Reference: CM/21/26/L

Address: Kents Farm House, Brookpit Lane, Climping, BN17 5QU

Proposal Listed building consent for replacement of 7 no. existing windows and 1 no. exterior door.

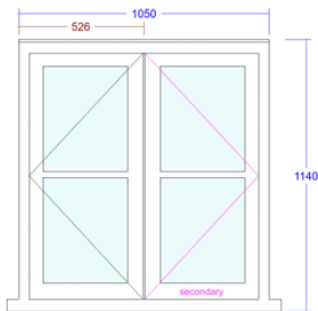
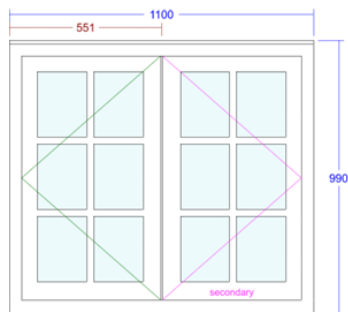
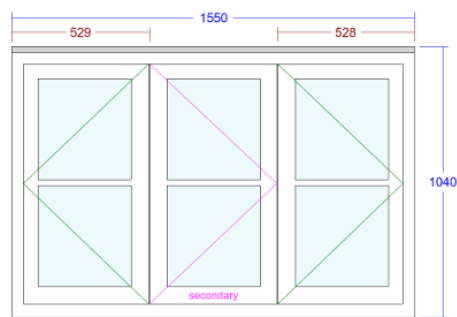
The proposed windows reflect the design/appearance and method of operation to ones that they are replacing. It is clear that the replacement casement windows have integral glazing bars, which is positive. It would be helpful to confirm if this is also the case for the sash window and door.
